Final Report - Corrections Required **Application No. ZONE-25-0021**

Report Date: 07/11/2025

Record Type : Zone Change

Document Filename : EPC Eng Comments_7.9.25

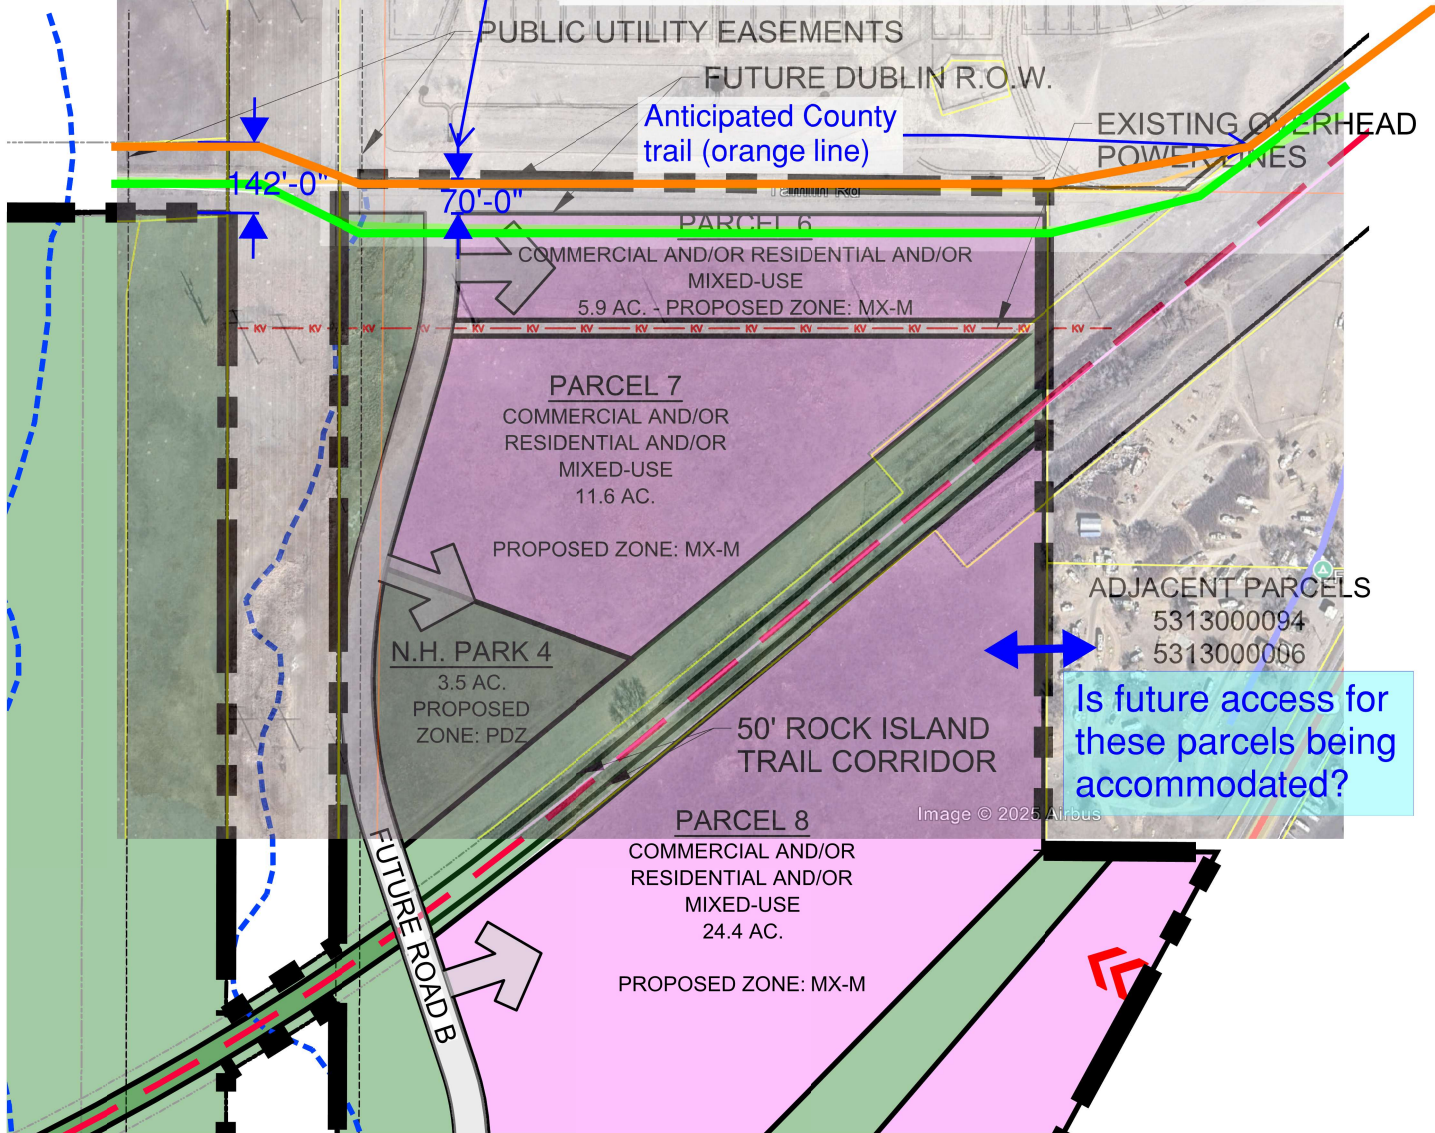
Why is ROW half of what is needed? (If Dublin is proposed to be split between incorporated and unincorporated areas, property acquisition from Falcon Highlands and EPC will be needed and County trail alignment (Rock Island and Falcon Hwy routes) in Tamlin Road ROW will need to be addressed.) (There was some coordination with Tim Roberts at the City in July 2022.)
